Subject: Whitehall Road West conditions 15, 17, 18, 19 and 28 - application 2025/92161

I am able to provide you with some feedback on these highway-related conditions.

ISLAND DETAIL
Scale 1:100

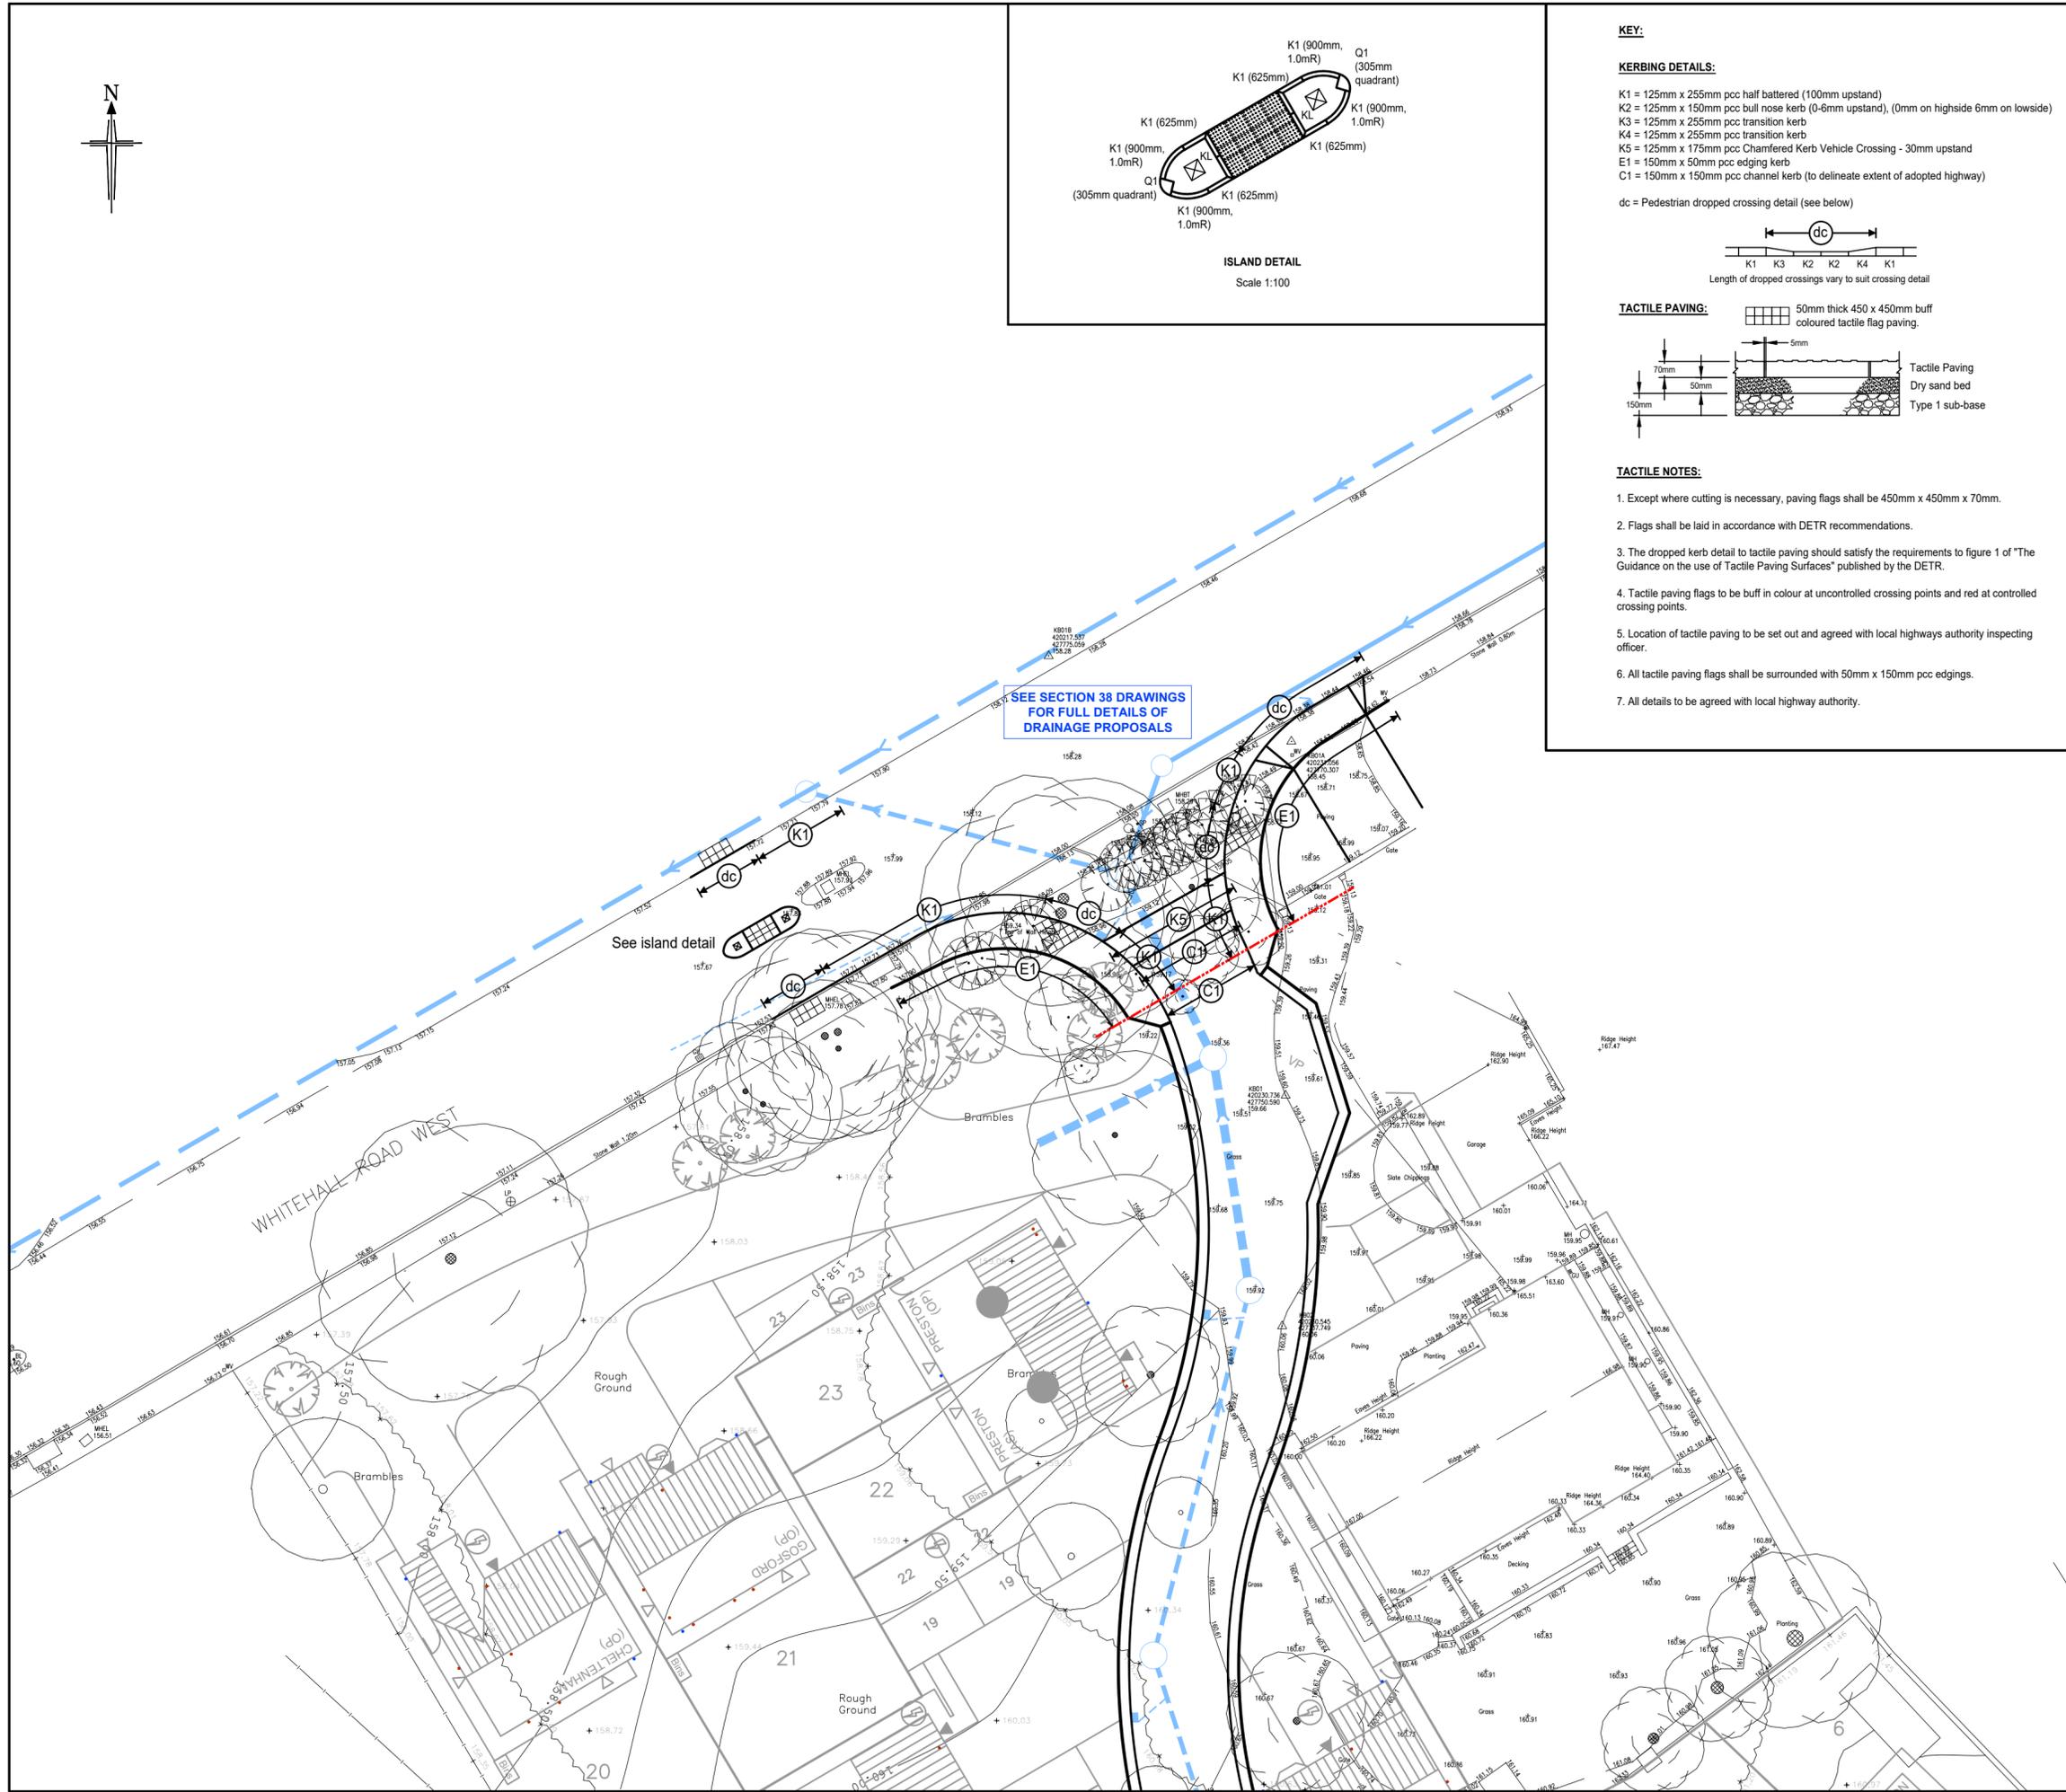
18. Prior to development commencing, a detailed scheme for the provision of highway improvement works including the re-siting of an existing pedestrian crossing traffic island on Whitehall Road West with associated signing and white lining shall be submitted to and approved in writing by the Local Planning Authority. The scheme shall include construction specifications, white lining, signing, surface finishes together with an independent Safety Audits covering all aspects of the work. All the agreed works shall be implemented before any part of the development is first brought into use. Reason: To ensure that the development does not adversely affect the safe and efficient use of the highway for existing and future users and to accord with the aims of Policy LP21 of the Kirklees Local Plan. This information is required pre-commencement to allow time for the scheme to be submitted, assessed approved so that it can be implemented before any part of the new development is occupied.

This condition will require the formal approval of the Councils 278 Engineer. The 278 Engineer has requested amendments to the design of the proposed access from Bradford Road and this condition cannot therefore be discharged.

This has all now been agreed and passed over to the S278 department who are to carry these works out on our behalf. I assume this is now acceptable and the condition can now be discharged.
